CITY OF ALBUQUERQUE

May 19, 2021

Re: Ziggis Coffee
5200 Menaul Blvd NE
Traffic Circulation Layout
Architect's Stamp **DATE not provided (H18-D073)**

TRAFFIC CIRCULATION LAYOUT
APPROVED

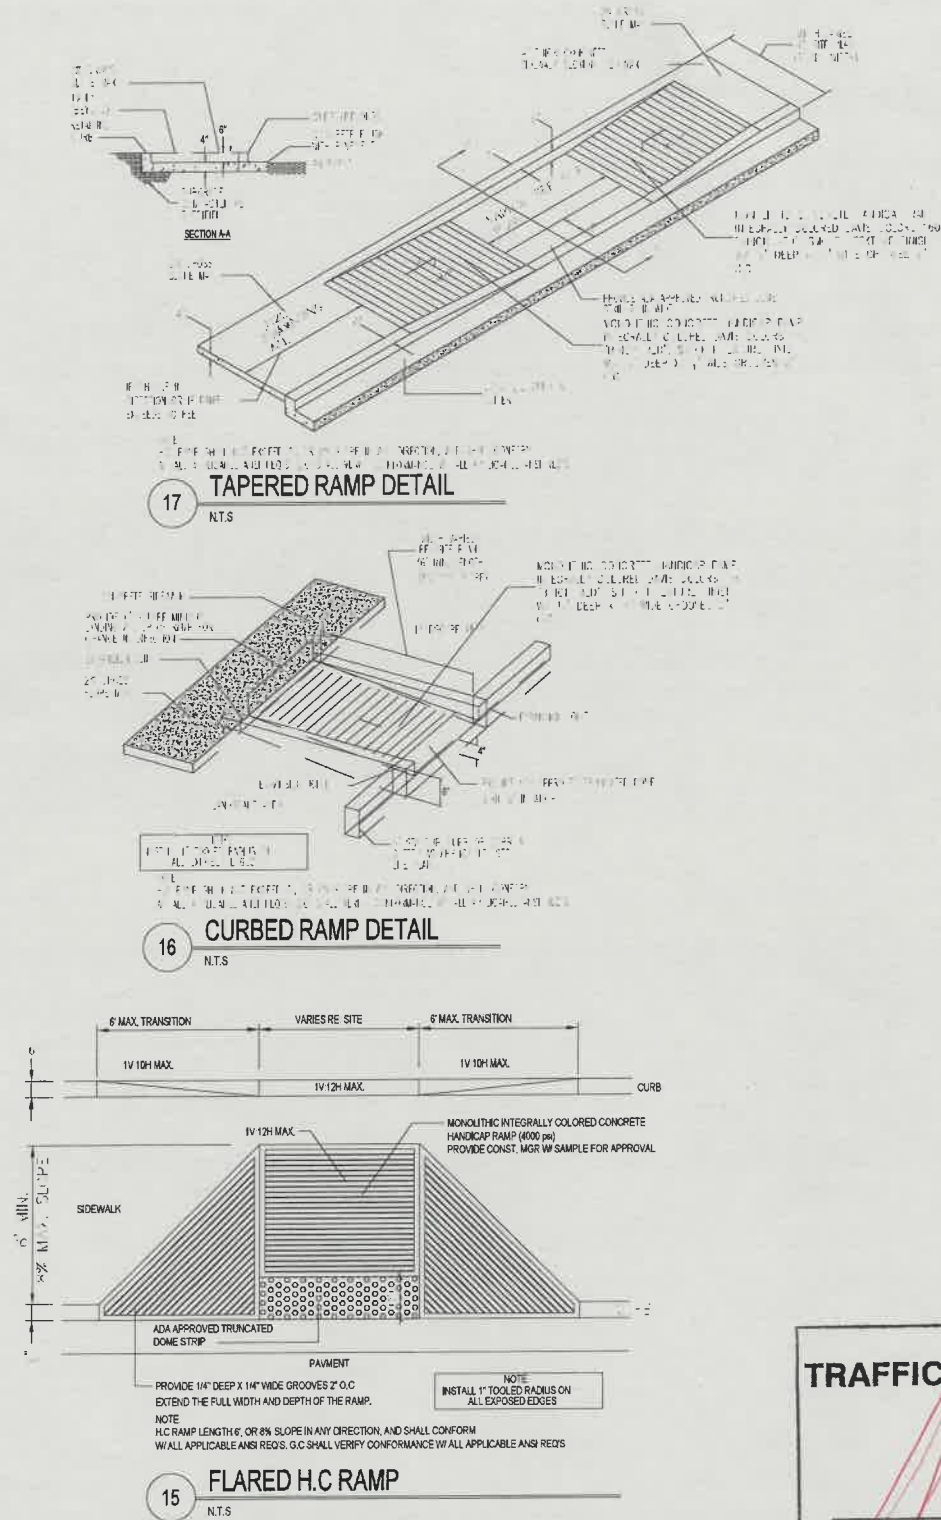
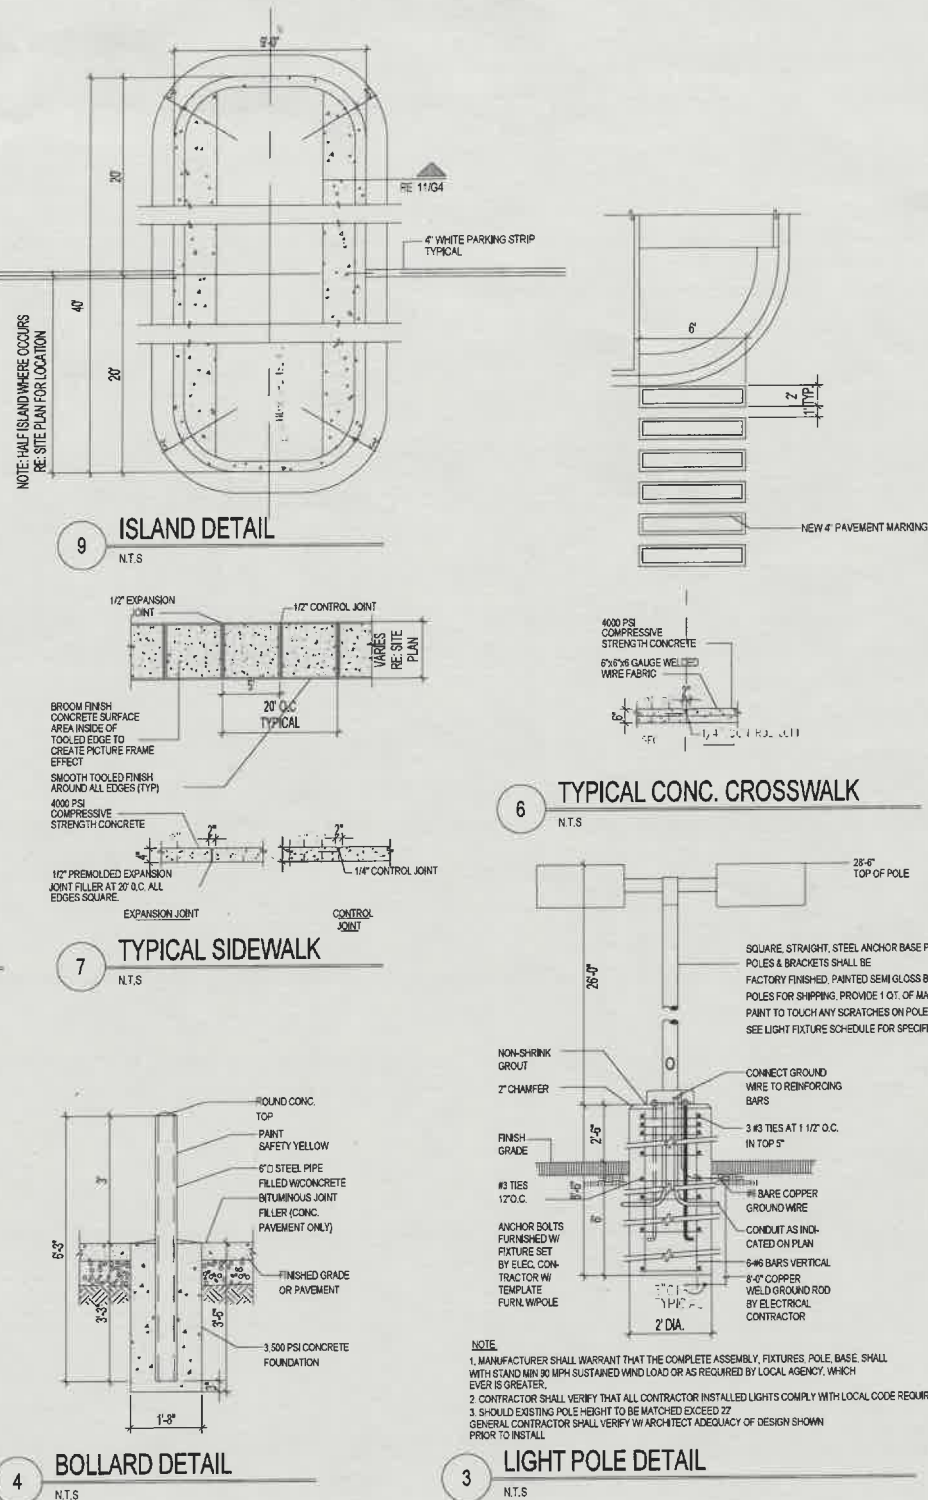
- PO Box 1293
- Albuquerque
- NM 87103
- www.cabq.gov
1. List the number of parking spaces required by the IDO as well as the proposed number of parking spaces including bicycle and motorcycle parking and discuss with Zoning. **It appears that the required parking stall don't match watch is being represented on the site plan. Please address this concern.**

4. Identify the right of way width, medians, curb cuts, and street widths on San Mateo and Menaul.
 5. Clarify existing property lines. Their appear to be discrepancy other corner for the configuration of property vs what AGIS shows?

7. The inside parameter of the property shows double line types but no notes to define it. Are these curbs? Provide notes to substantiate any proposed and/or existing infrastructure on site plan and if needed provide details.

8. **San Mateo entrance/roadway segment:**
 - The closes driveway to the intersection will need to be closed. A note will need to be provide to define this action.

- The existing entrance off San Mateo is too wide for an egress movement. The concern is that the public will use it as an ingress movement because the width is 26 ft wide. Suggest modifying the entrance width to 20 ft to deter/avoid any traffic safety issues (conflicting vehicle movements).

- The existing driveway is not current/update ADA so provide a new driveway per COA standards.
- The pavement markings will need to be located onto private property located on existing driveway.

- The existing driveway closes to the intersection will need to be closed. A note will be needed to define this action.
- The eastern portion of the driveway is not current/updated ADA. Please modify per COA standards
- The western portion of the driveway is curb return but you didn't provide a 6 ft valley gutter, ADA ramp details w/detectable warning surfaces and construction notes on how you are going to tie in existing sidewalk onto proposed ramp and tie in 6 ft valley gutter into existing gutter plan on the east side of entrance.

11. What is the status of the existing alley way to the south of the lot? Is it paved? Can the alley way be accessed from the site?
12. ADA curb ramps must be updated to current standards and have truncated domes installed at the corner San Mateo/Manual and proposed/modified Manual entrance. Will the alley way be used as an ingress/egress movement?

13. Motorcycle parking space: The proposed location of this stall is far from the building entrance. Please modify it's location and provide a sign face detail.

20. List radii for all curves shown; for passenger vehicles. Radius for **delivery trucks, fire trucks, etc. is 25 ft. or larger.**
21. Per the IDO, a 6 ft. wide ADA accessible pedestrian pathway is required from the public sidewalk to the **building entrances. Please clearly show this pathway and provide details.**

25. **“Do Not Enter” signage needs to have two signs coming out of drive thru lanes (one on each side of the departing lane).** Please show detail and location of posted signs and striping.

29. Please provide a sight distance exhibit is not accurate. Please adjust this exhibit fronting both San Mateo and Manual since the roadways are divided and only require one direction for stopping site distance and mini clear sight triangle for driveways(see Attachment).

30. Show the clear sight triangle and add the following note to the plan: "Landscaping and signage will not interfere with clear sight requirements. Therefore, signs, walls, trees, and shrubbery between 3 and 8 feet tall (as measured from the gutter pan) will not be acceptable in the clear sight triangle.

PROJECT TITLE ZIGGIS COFFEE		JOB NO. 5200 MENAUL BLVD. NE ALBUQUERQUE, NM	
PROJECT MANAGER Project Manager		DRAWN BY: Project Manager	
SHEET TITLE SITE DETAILS		SHEET NO. G6	
DATE 06-04-21	SCALE	SHEET

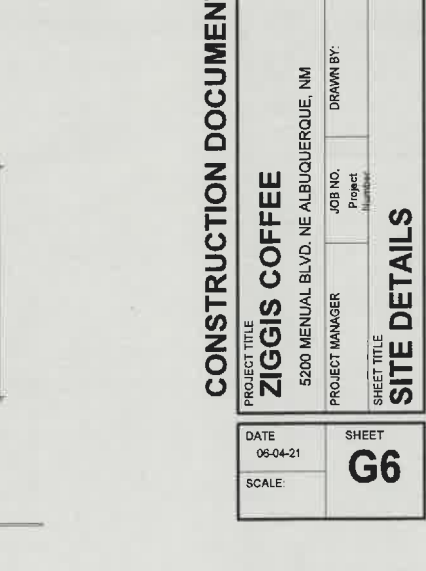
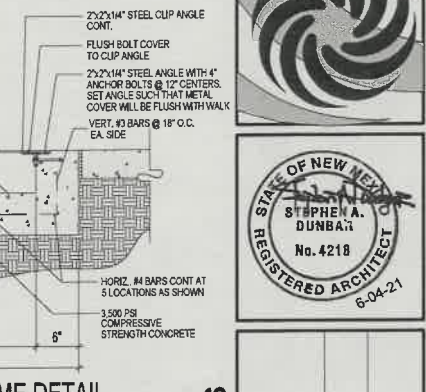
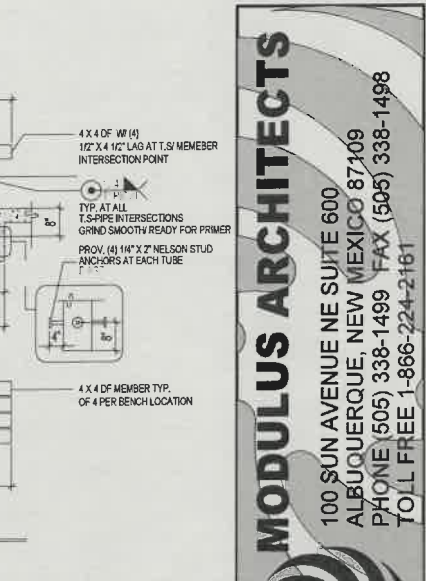
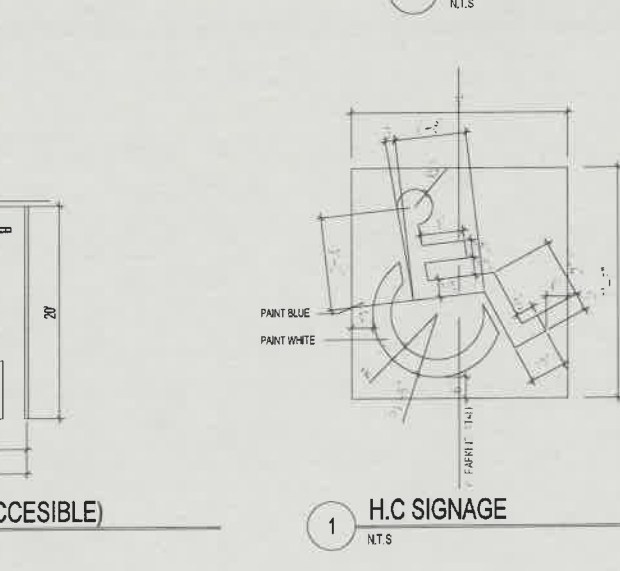
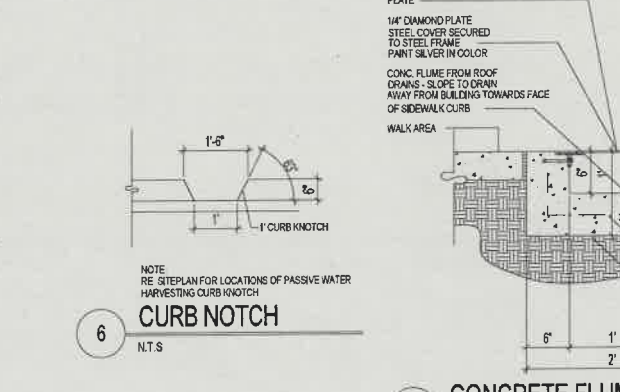
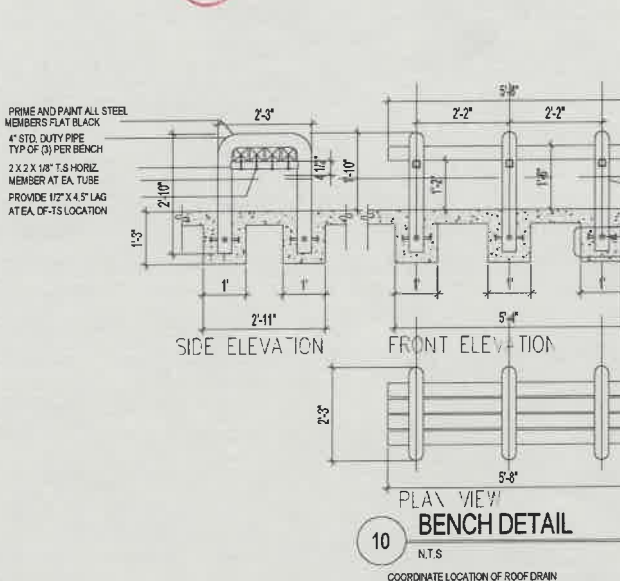
27. **Sheet G5 Bollard detail:** Add note to paint bollards traffic yellow.
28. The minimum drive through lane width is 12 feet with a 25 foot minimum radius (inside edge) for all turns. (A 15 foot radius can be used with an increase in lane width to 14 feet). Please dimension all lane widths and radii.
